# grading review1.pdf Markup Summary

TYPICAL SECTION 50' R.O.W.
RESIDENTIAL URBAN LOCAL
NOT TO SCALE

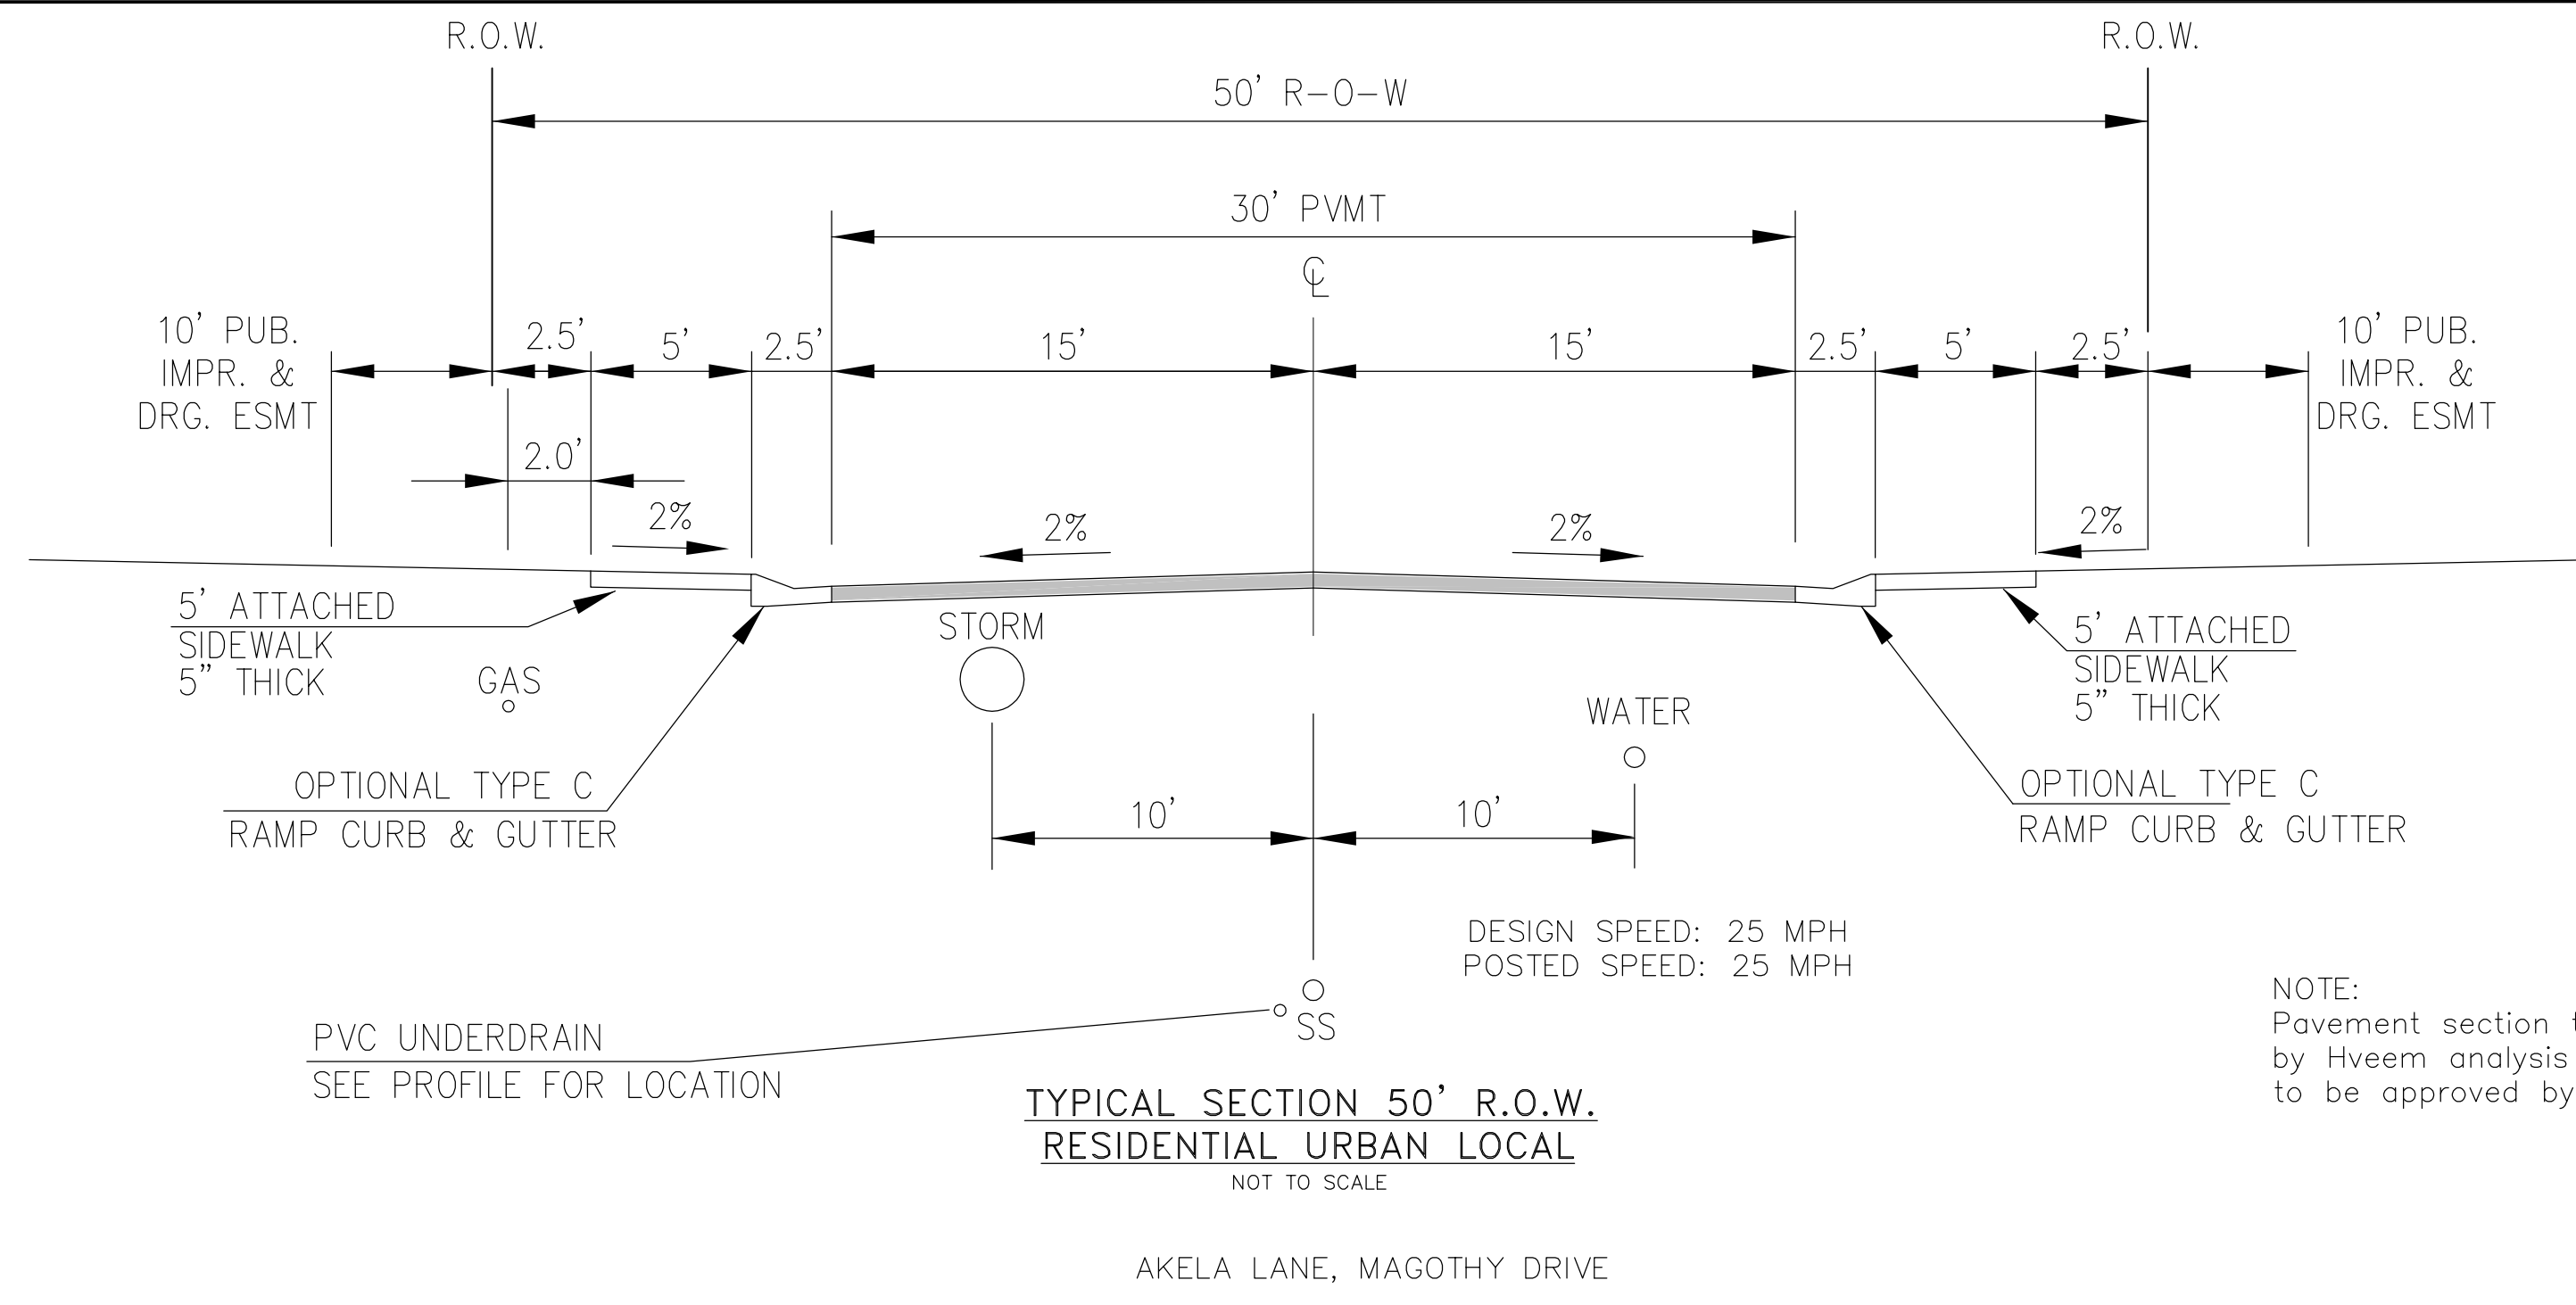
Per typical section on CD's, public improvement easement is 5'. Update sections between plan sets to be consistent.

changed to 5'

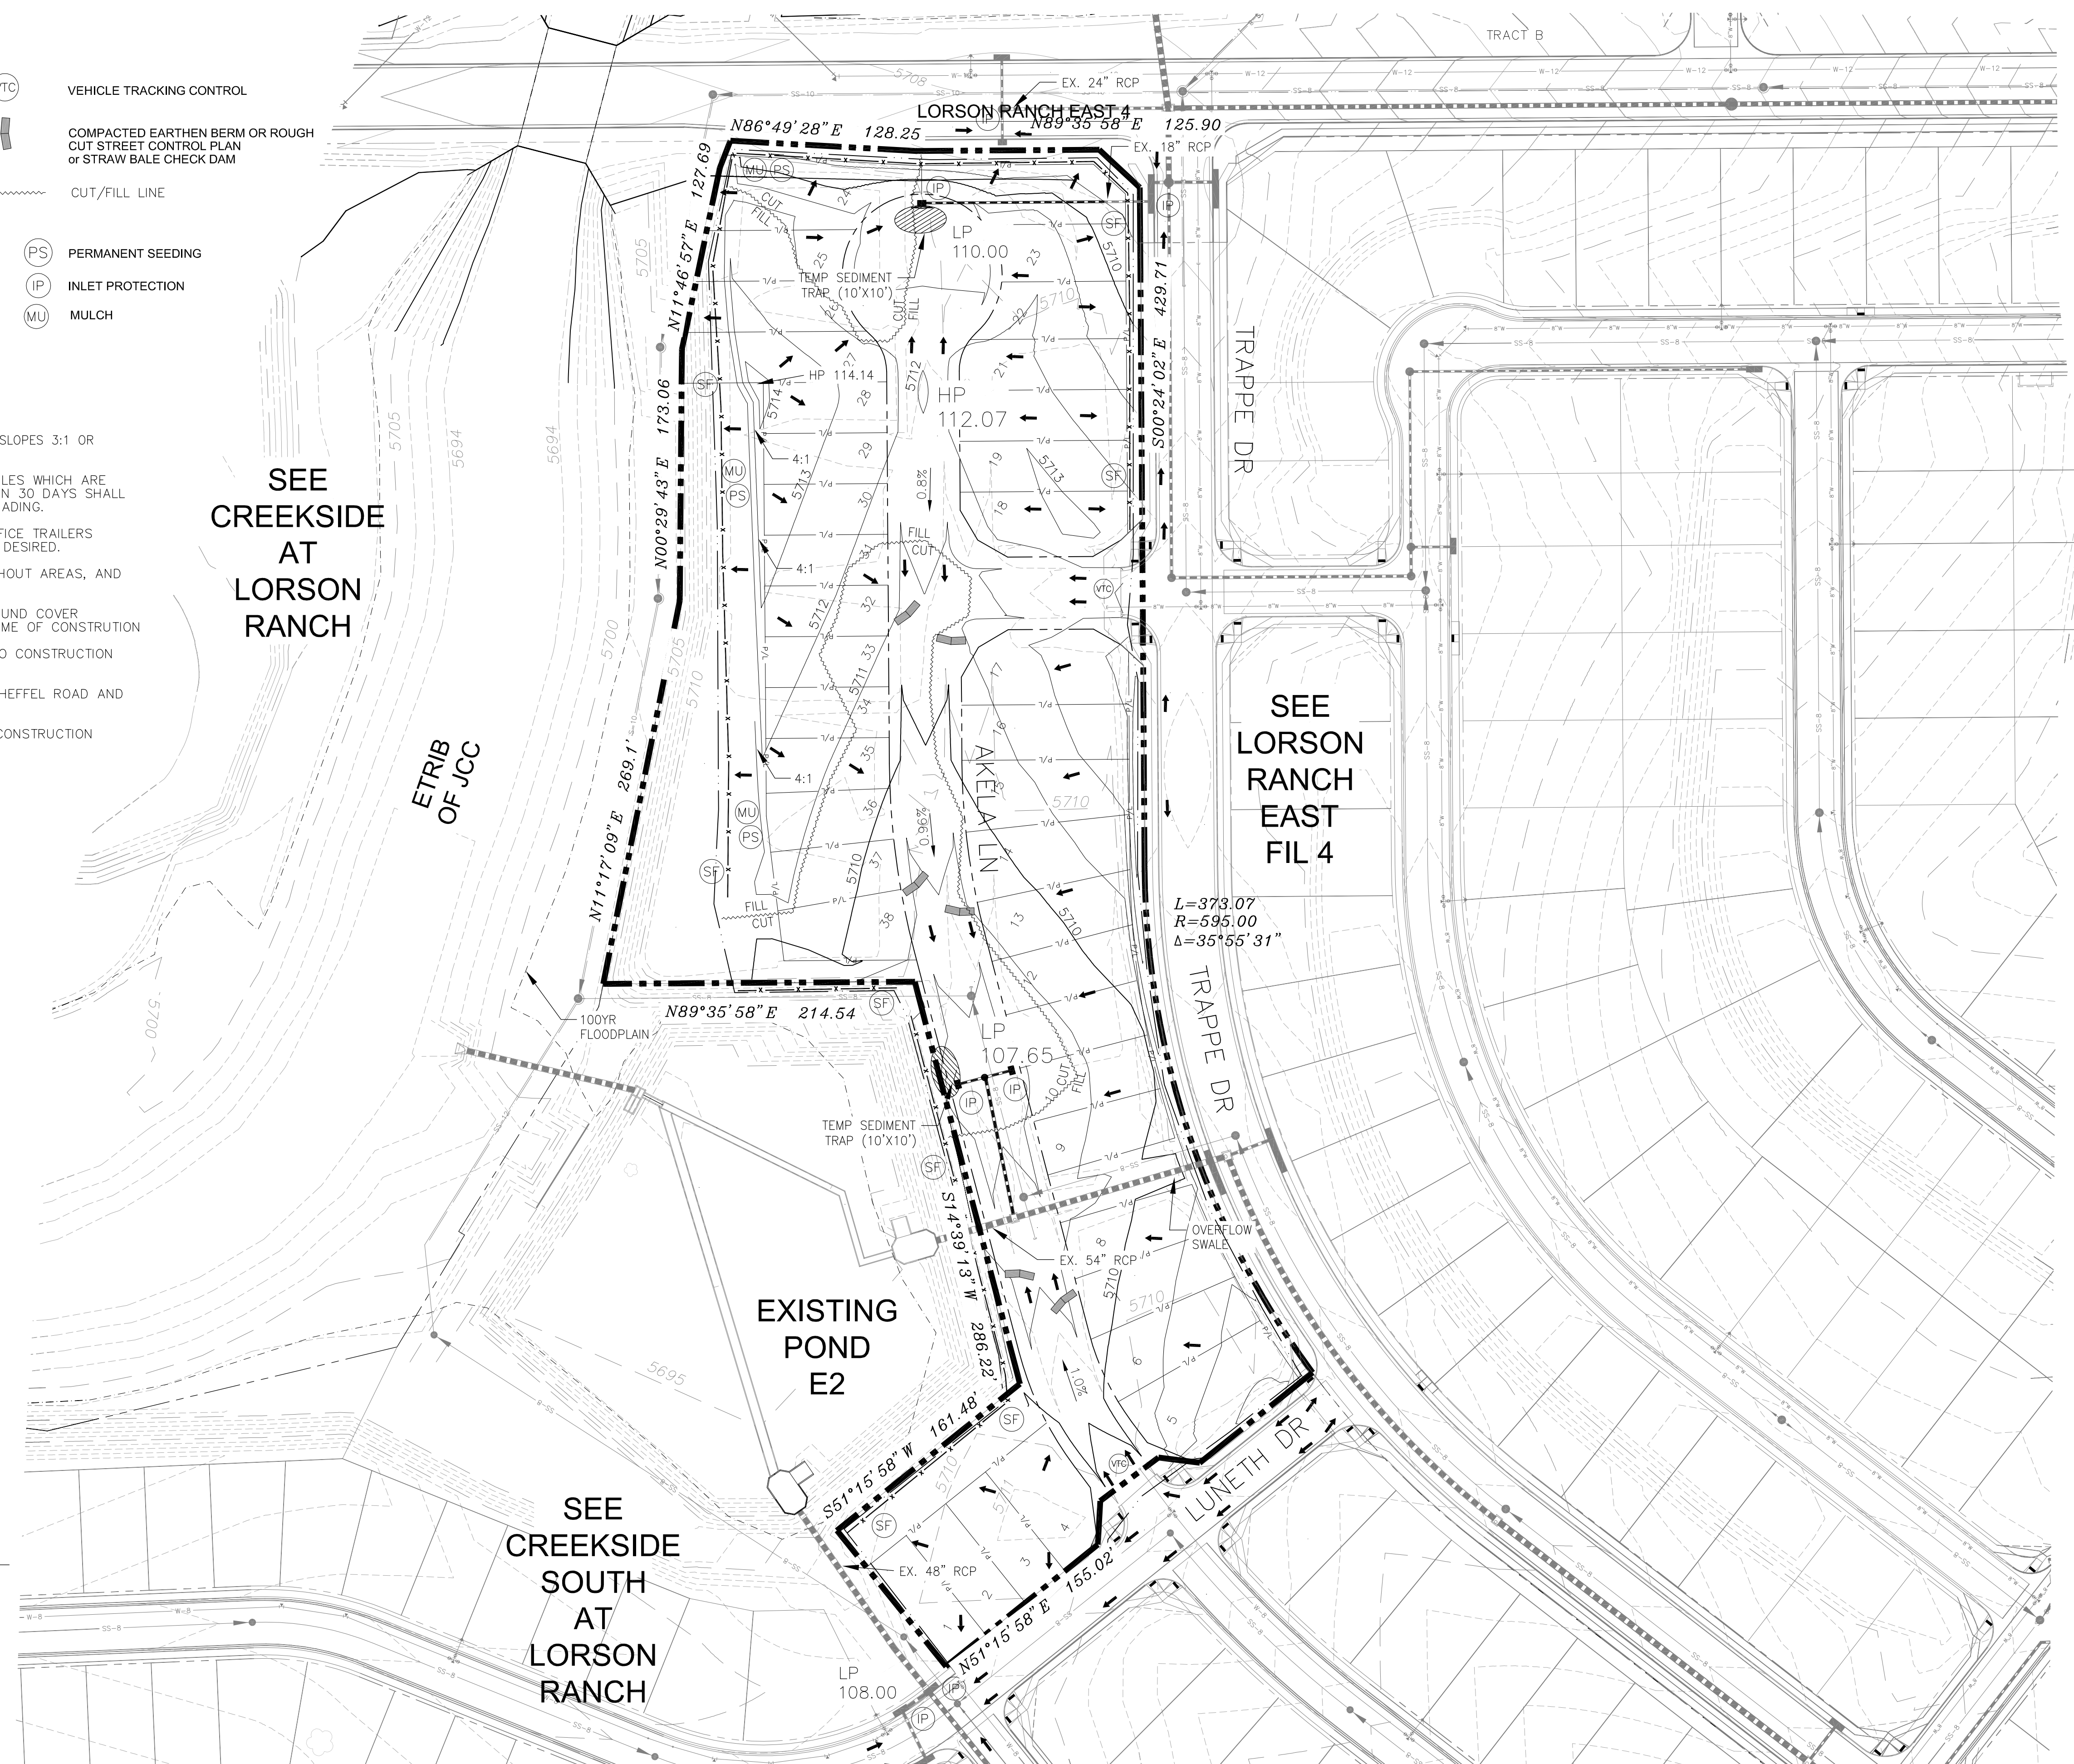
gray out this forebay so it is clear that it is existing and not being modified with this project.

Just to help out our tracking, put "(built with Creekside South at Lorson Ranch F1, EDARP File Number SF2017)" in parenthesis here.

forebay shaded back

text added
